**Re: Comments on SSD-50505215 EIS for Bullawah Wind Farm**

Please find below the comments from Hay Shire Council on the Bullawah Wind Farm EIS on exhibition until 23/9/2024:

Figure 4 Transport route - Hay to site

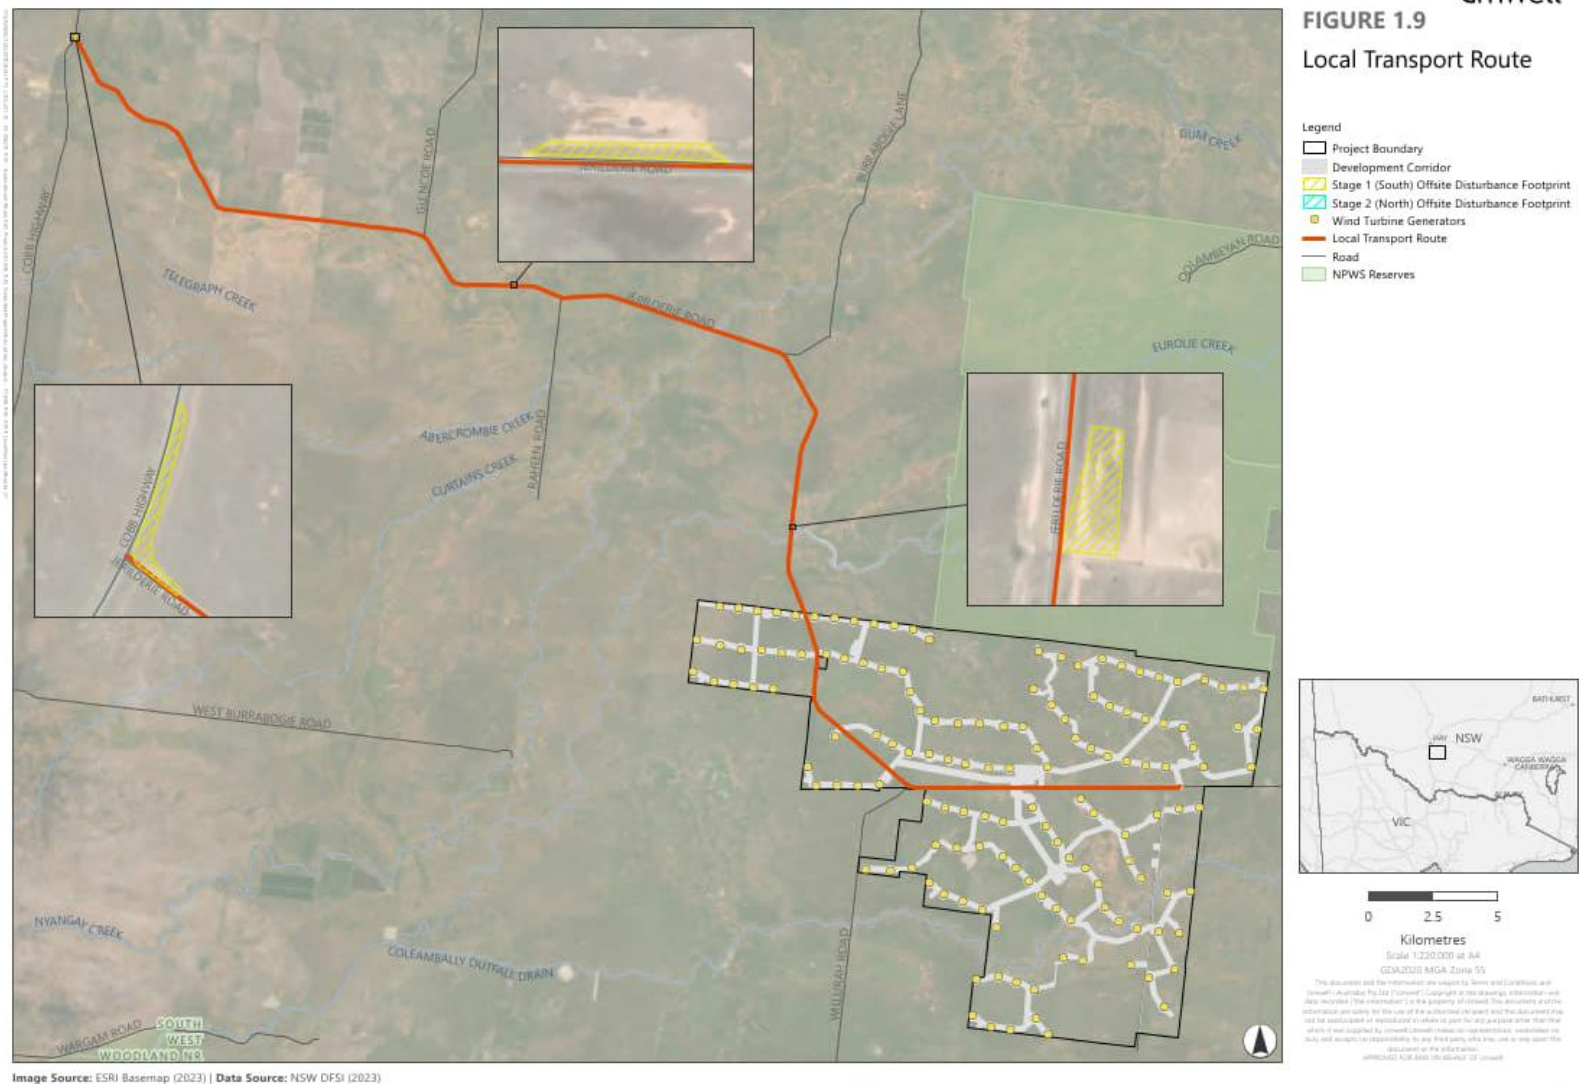
- Page 80 – transport routes – note comment that upgrades to the transport routes from Port of Newcastle to Hay is not part of the project.
- Page 81-82 – local transport routes – Jerilderie Road would not be able to withstand the proposed heavy vehicle loading required. Concurrence is required with Council in regards to road upgrade, dilapidation survey, intersection designs, etc.

- Page 180 – may require a Fisheries Permit when working in or near a water course.
- Page 254 - local transport routes – Jerilderie Road would not be able to withstand the proposed heavy vehicle loading required. Concurrence is required with Council in regard to road upgrade, dilapidation survey, intersection designs, etc. There is an expectation that the developer will maintain Jerilderie Road for the course of the project.
